THE TRAILS AT ASPEN RIDGE FILING NO.5
A SUBDIVISION OF TRACT H OF THE TRAILS AT ASPEN RIDGE FILING NO.3 LOCATED IN THE WEST 1/2 OF SECTION 9,
TOWNSHIP 15 SOUTH, RANGE 65 WEST OF THE 6TH P.M. EL PASO COUNTY, COLORADO
SHEET 1 OF 3

DATE: 12/25/22
 SHEET 1 OF 3
 PDB, SF-21-038

THE TRAILS AT ASPEN RIDGE FILING NO.5
A SUBDIVISION OF TRACT H OF THE TRAILS AT ASPEN RIDGE FILING NO.3 LOCATED IN THE WEST 1/2 OF SECTION 9,
TOWNSHIP 15 SOUTH, RANGE 65 WEST OF THE 6TH P.M.
EL PASO COUNTY, COLORADO
SHEET 2 OF 3

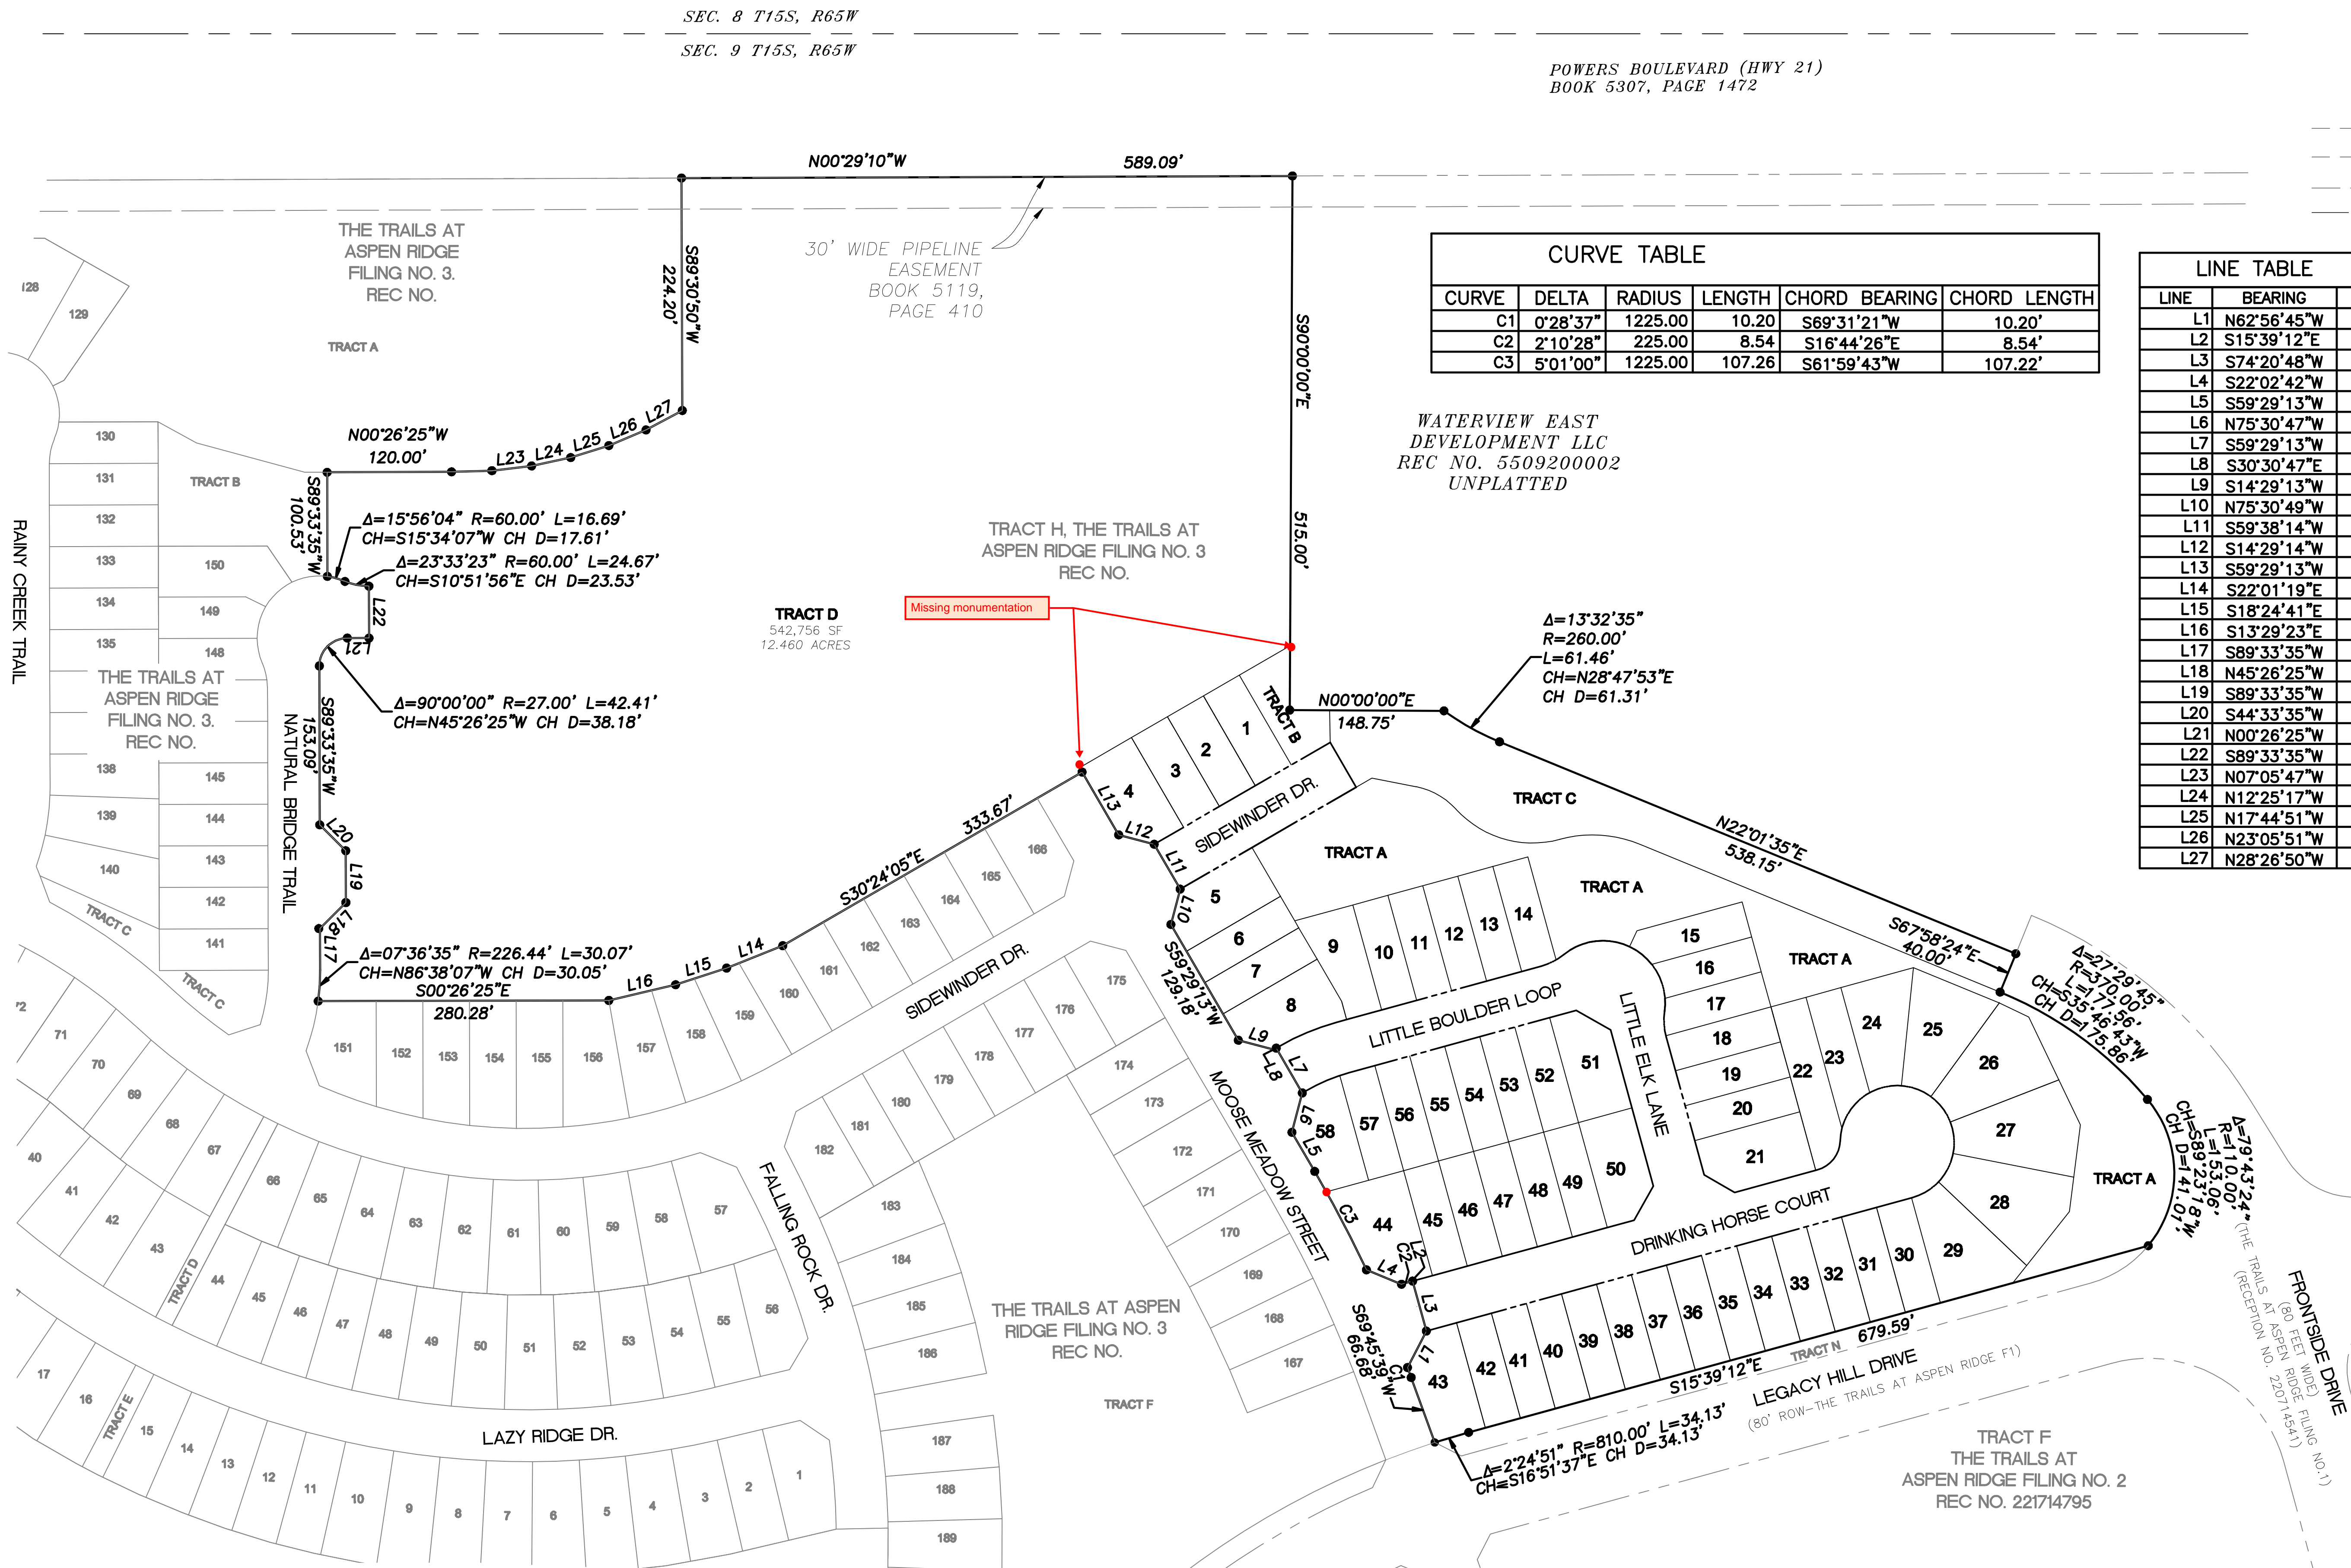
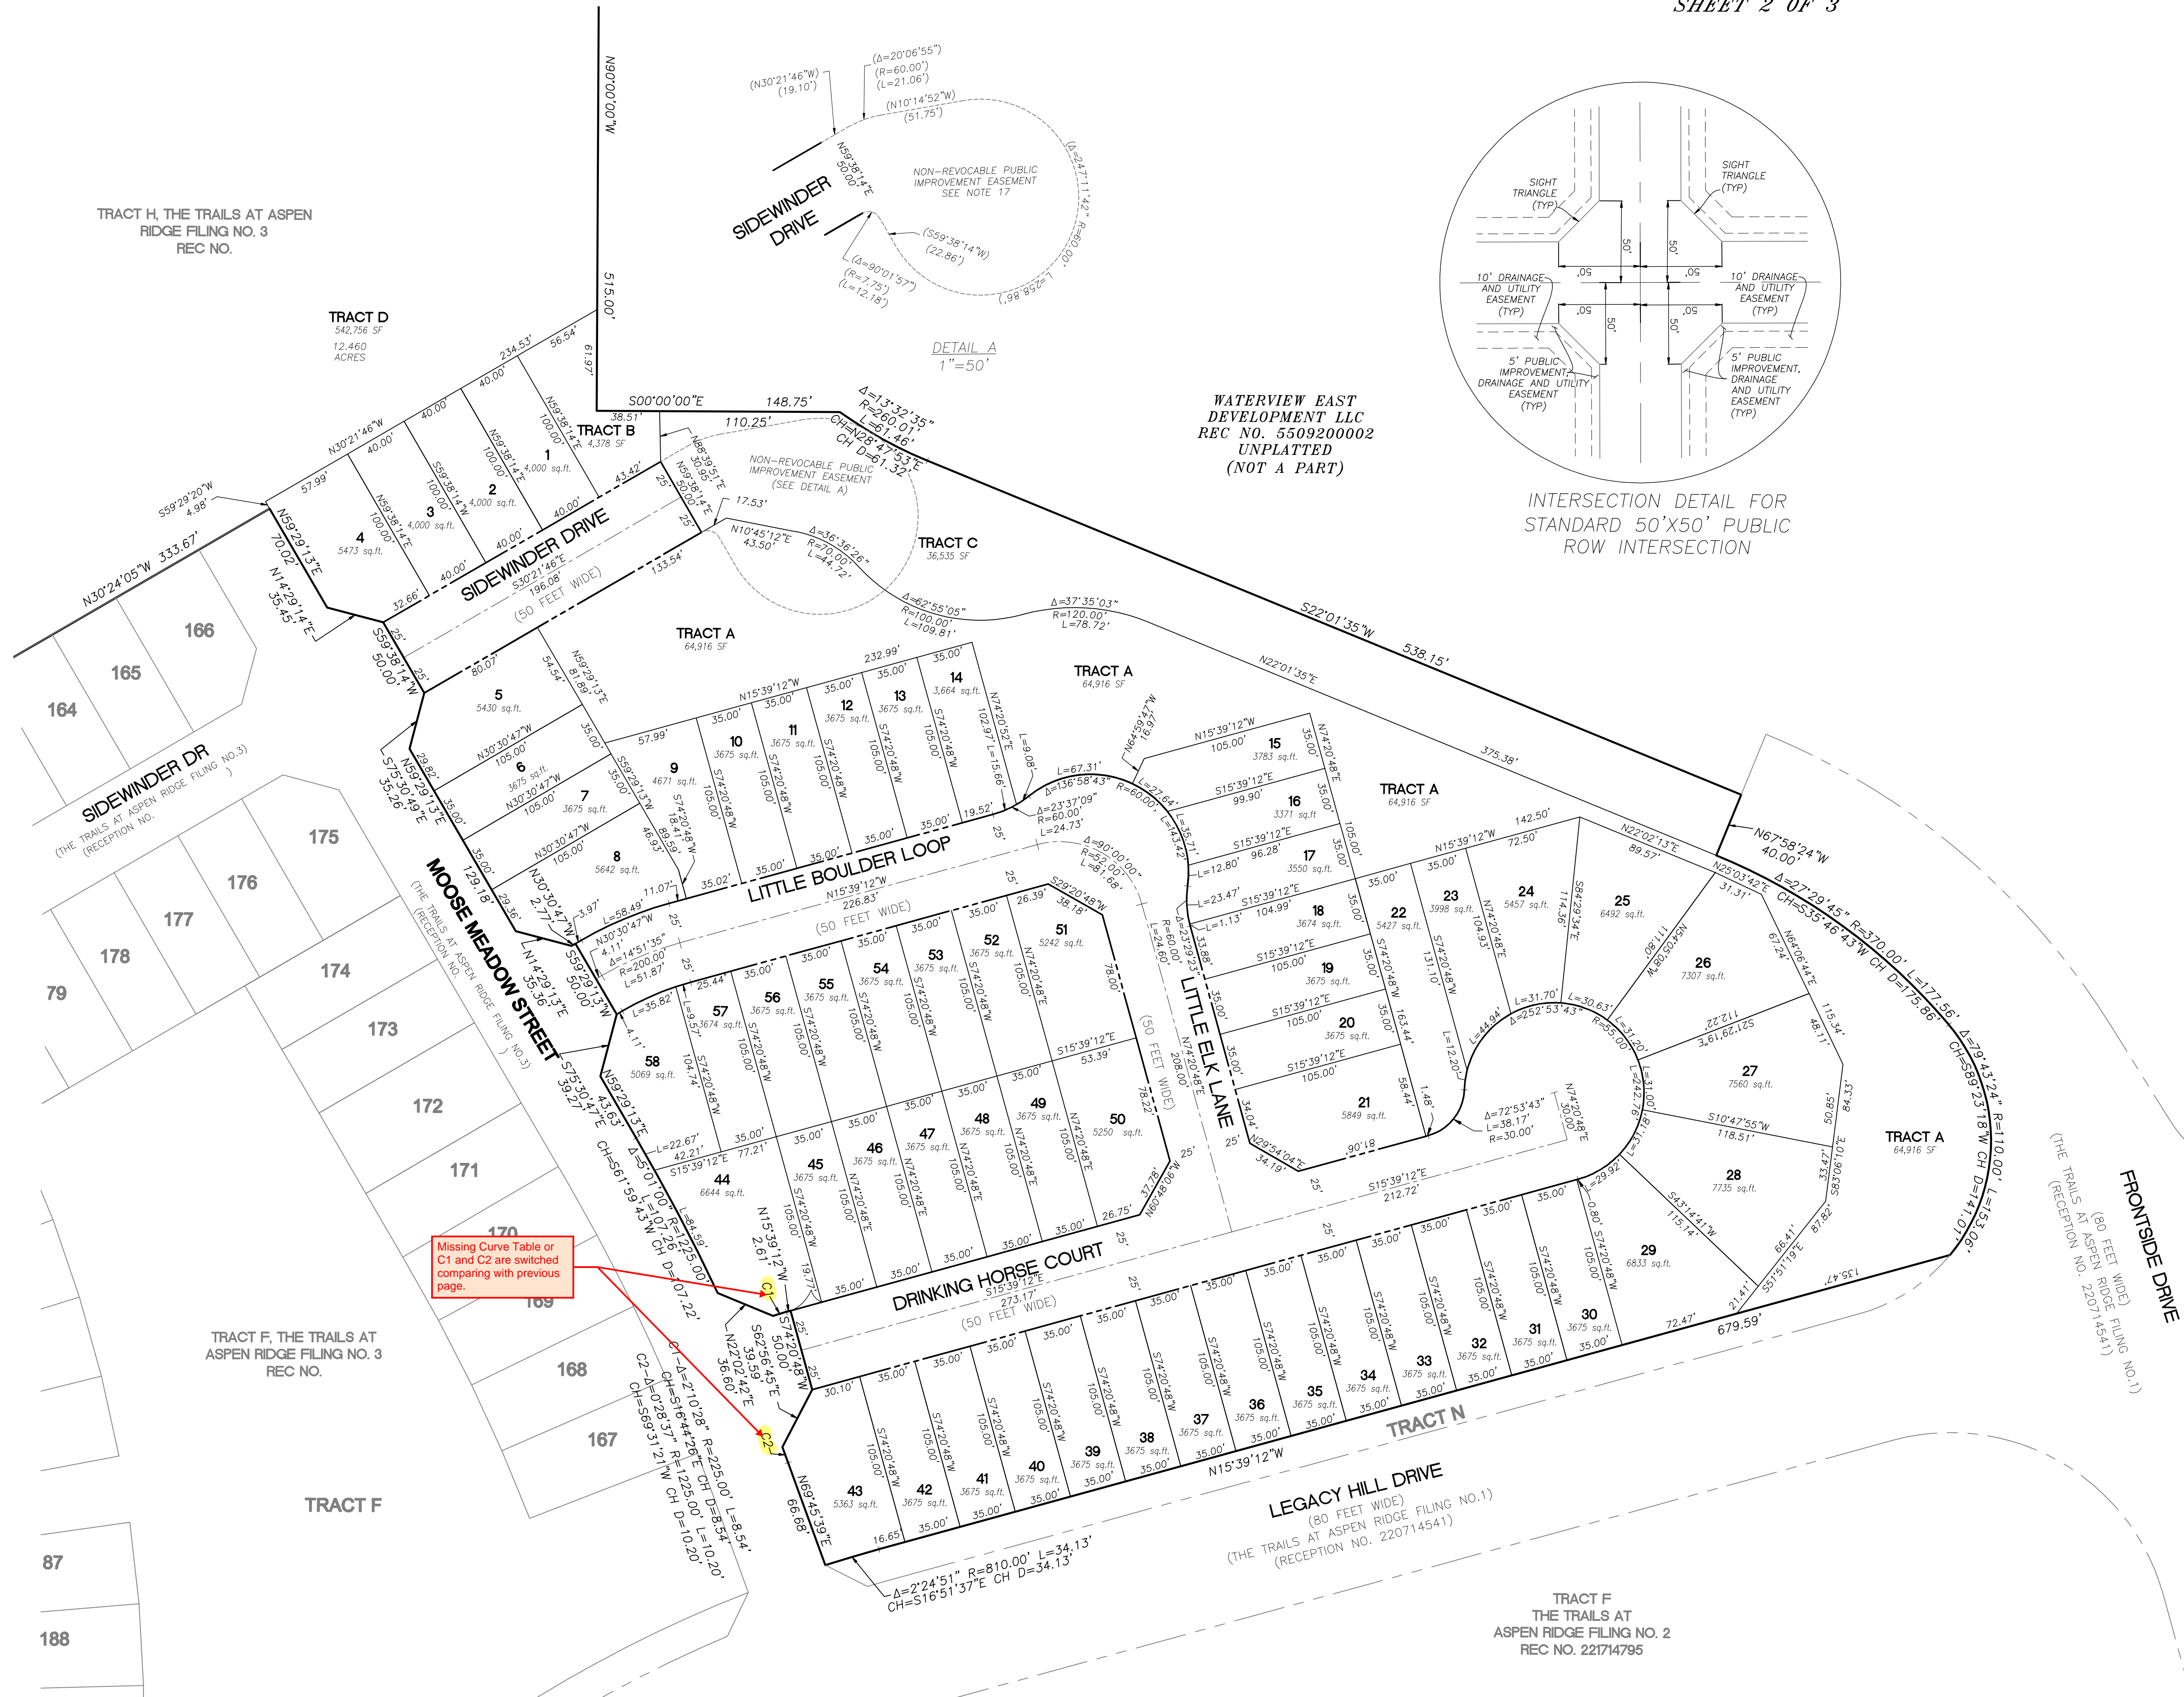
UNRESOLVED PREVIOUS COMMENT: SOILS & GEOLOGY REPORT INDICATES GEOLOGIC HAZARDS ON THE PROPERTY AND MITIGATION REQUIRED. PLEASE DETAIL GEOLOGIC HAZARDS ON THE PLAT. PLEASE INCLUDE THE SOILS & GEOLOGY NOTE.
